**Consultation Response from KC,
Trees**

**2023/91405 Part of former St Luke's Hospital site, Blackmoorfoot Road, Crosland Moor,
Huddersfield, HD4 5RA**

**Erection of foodstore (class E) with associated access, parking, servicing area and
landscaping**

Date Responded: 22.01.2024

Appendix 6: Tree Impacts Plan

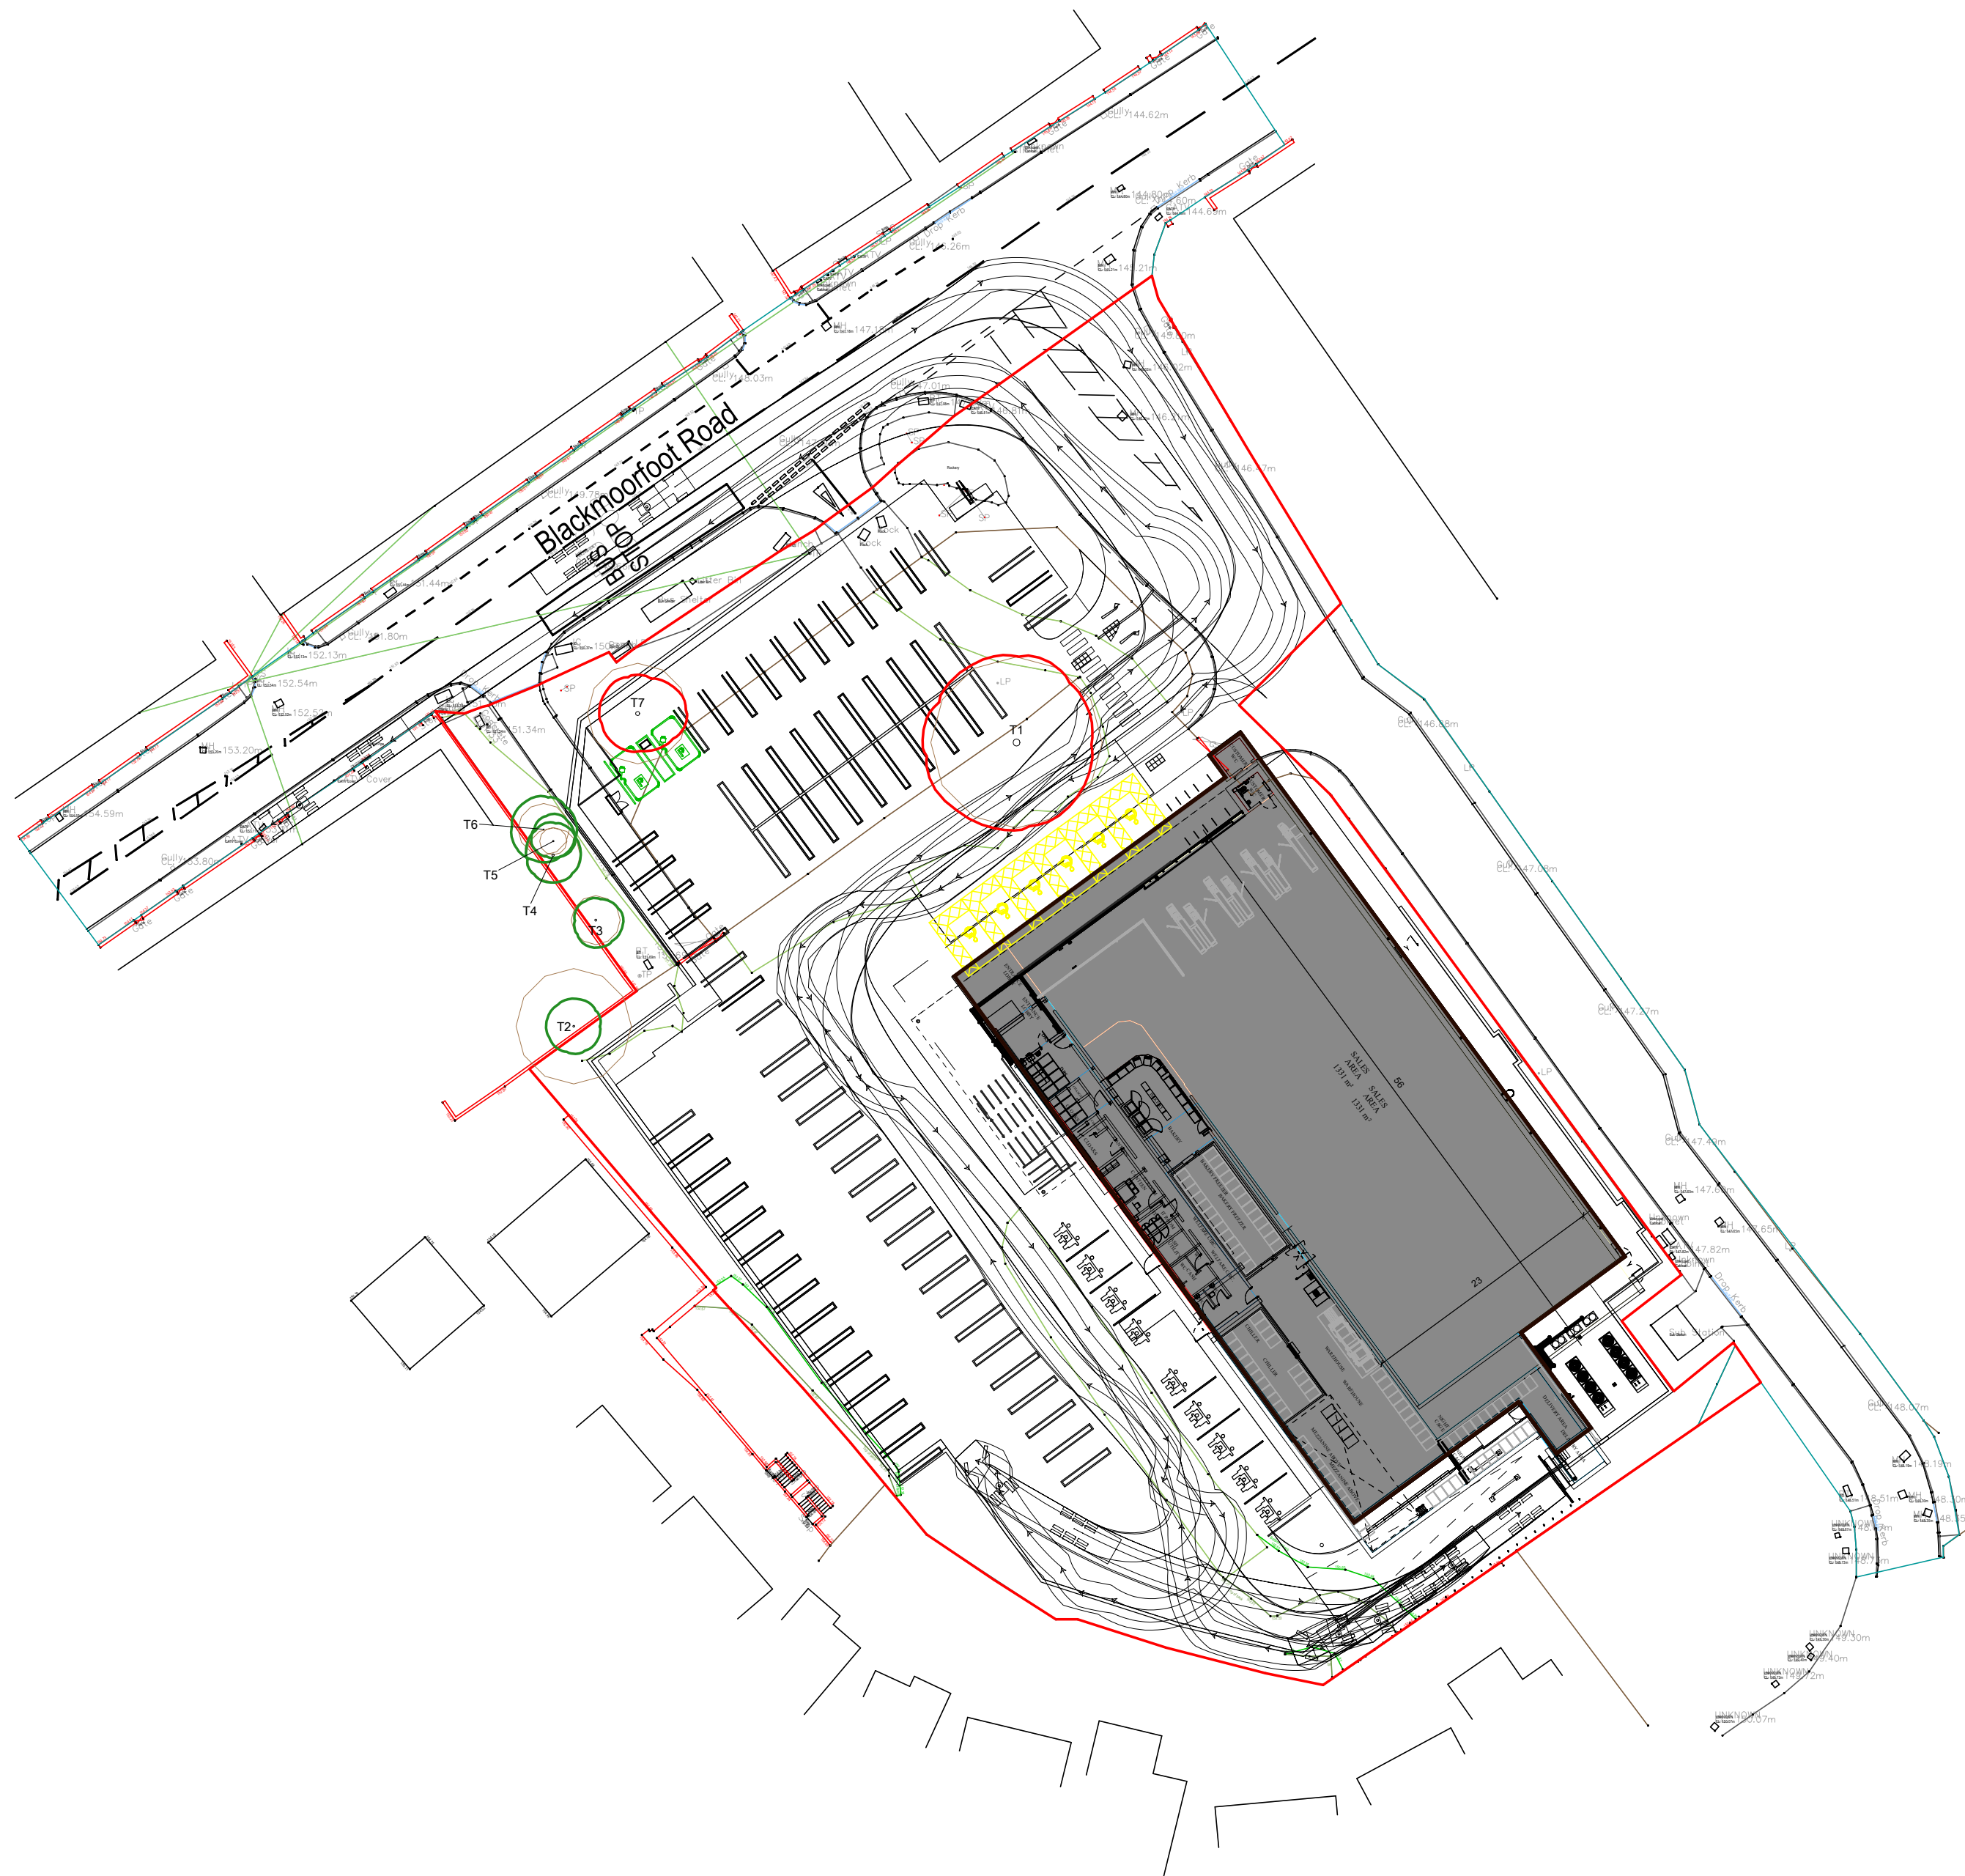
As mentioned in AWA Tree Consultants report (AWA5710) dated October 2023, The sycamore (10/94/t68) is rated as a category A tree. Not only is it a category A tree but it also provides a large amount of amenity value to the wider area as it is situated so close to a main road and surrounding properties.

The current proposals have not taken into consideration the high value of this tree and there is an argument for there being a design solution that incorporates this tree into the site as a feature. There is a **holding** objection from a trees perspective as the proposal conflicts with adopted Kirklees local plan policy 33 and 24 (i) which reads: The Council will not grant planning permission for developments which directly or indirectly threaten trees or woodlands of significant amenity. Proposals should normally retain any valuable or important trees where they make a contribution to public amenity, the distinctiveness of a specific location or contribute to the environment.

The horse chestnut (10/94/t69) is also a high amenity tree but is a poorer specimen and is showing signs of decline and therefore would be the preferred choice, should one of these trees have to be removed to facilitate the development.

Appendix 3: Landscape Plan

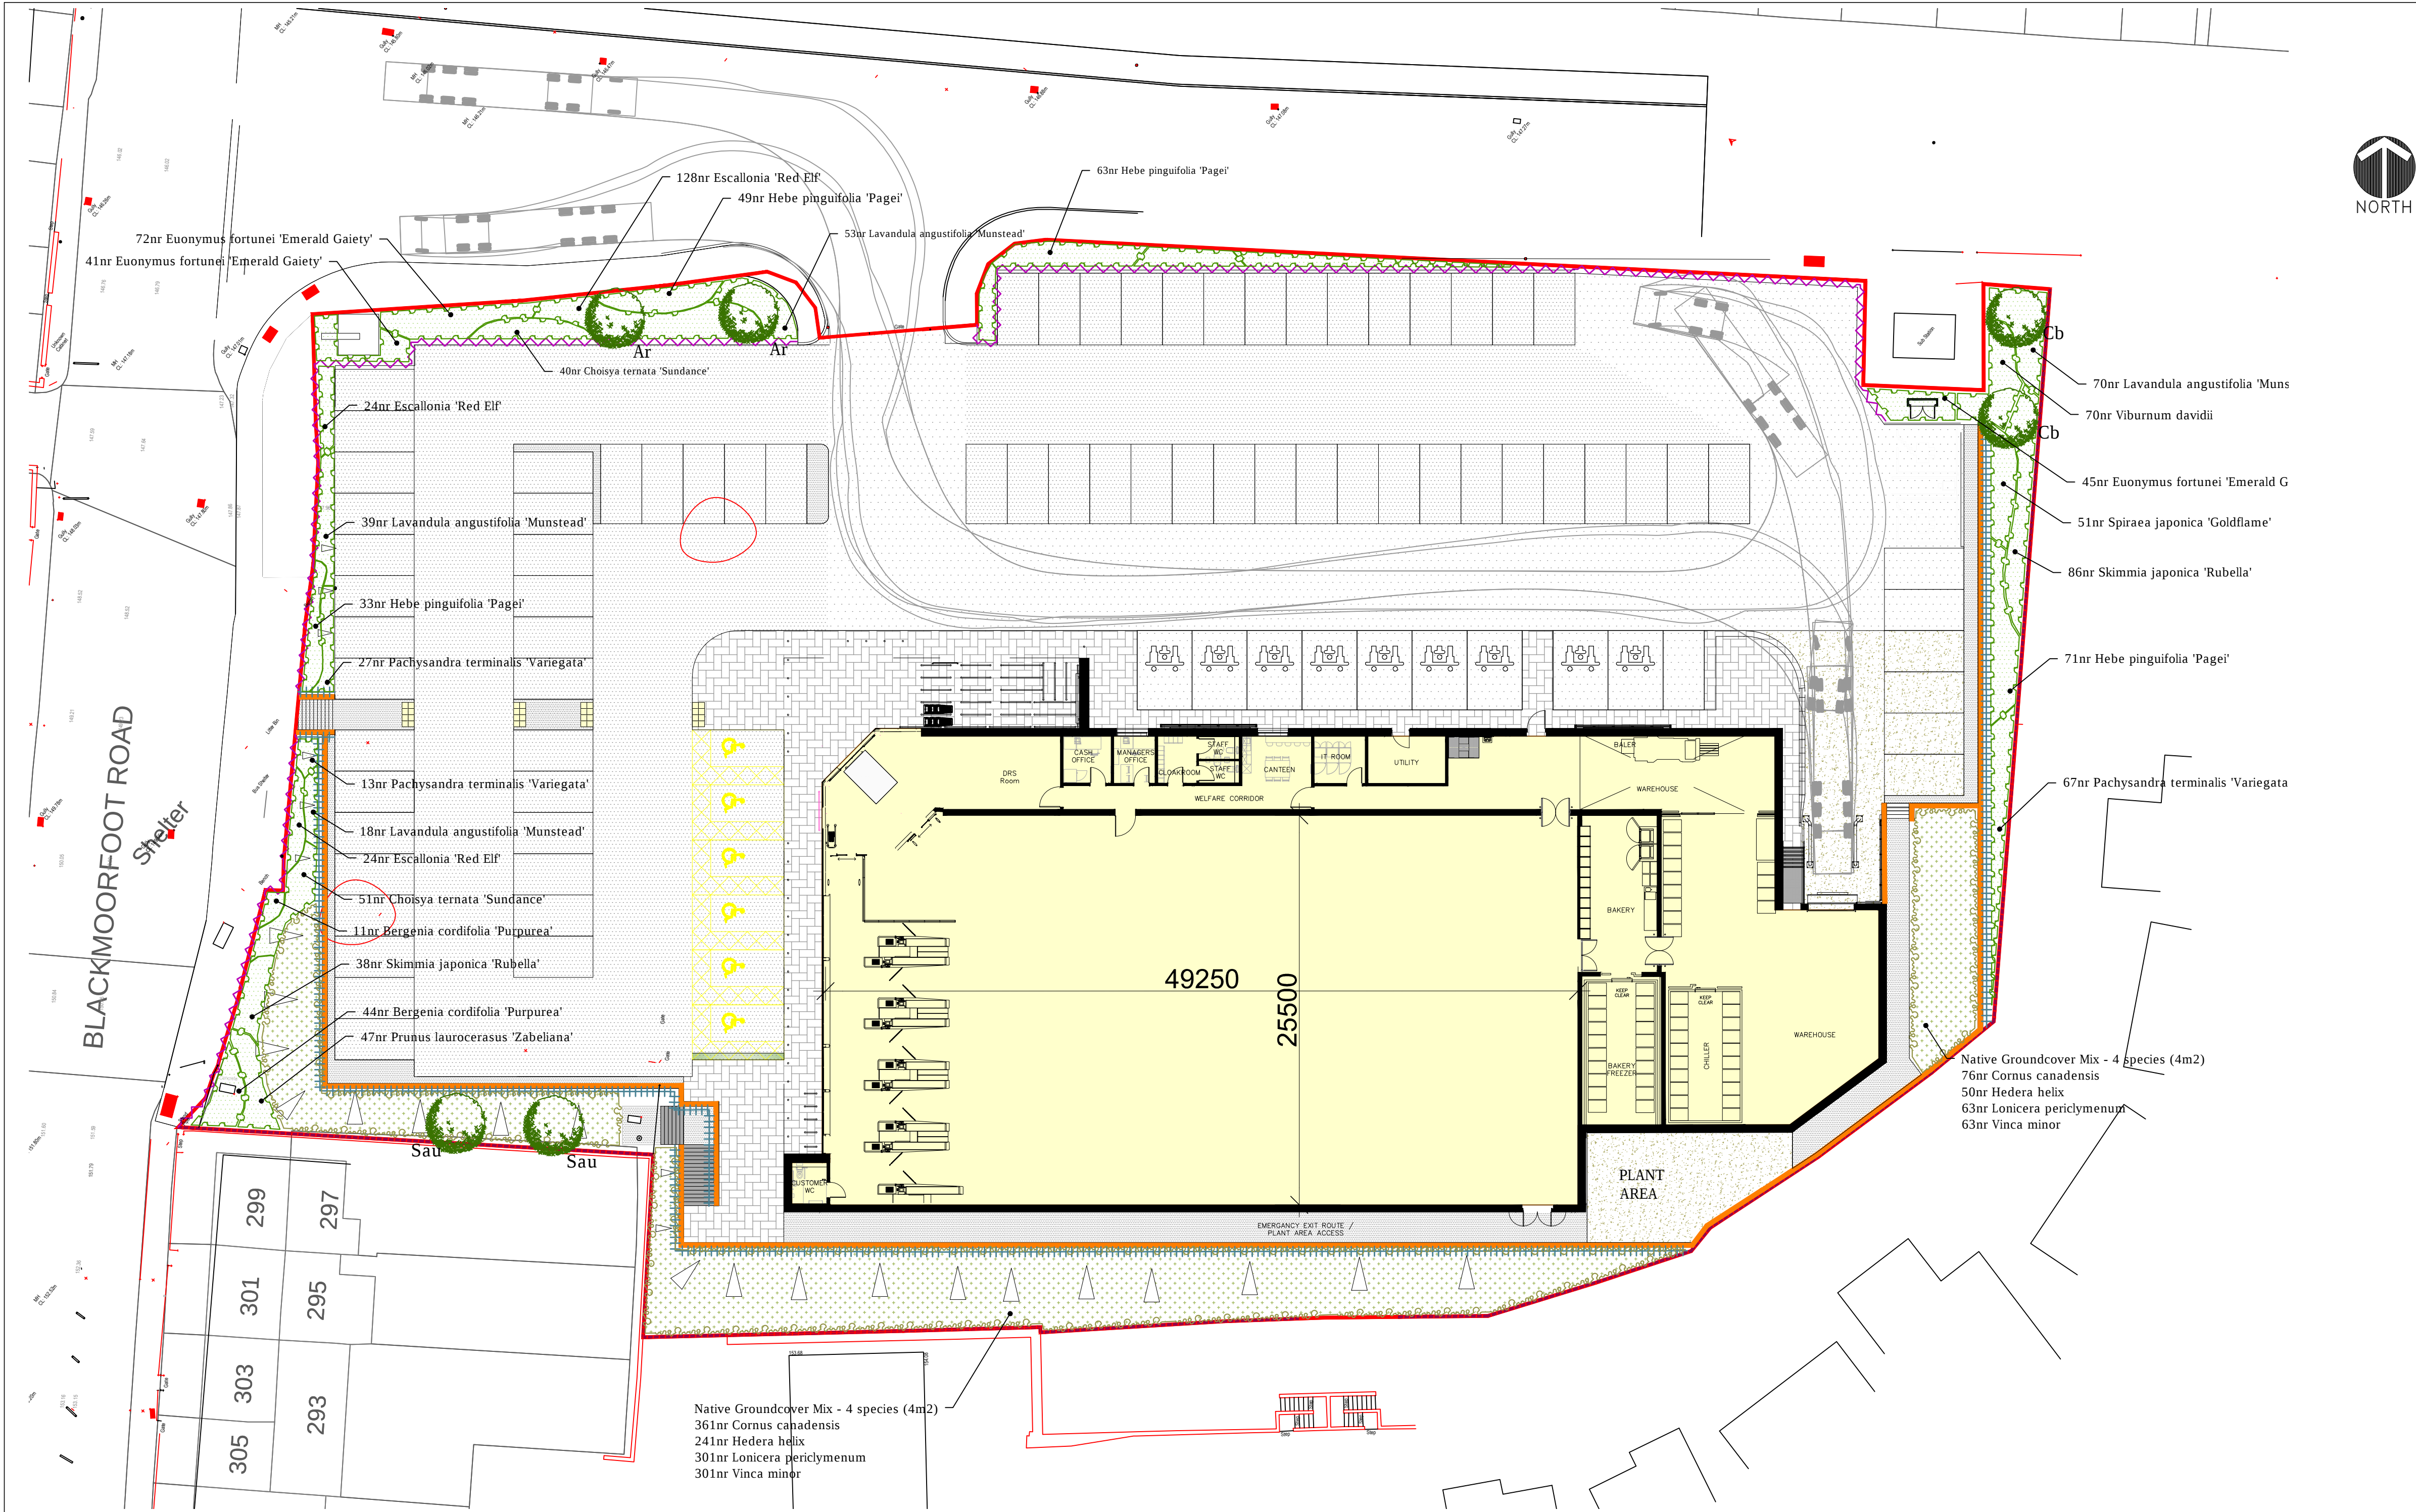
The current proposals also show no trees being planted on the new site. A planting scheme put in place to mitigate against the loss of the current trees on site would be preferable. For example, they could be incorporated into the car park using islands and shrub beds.
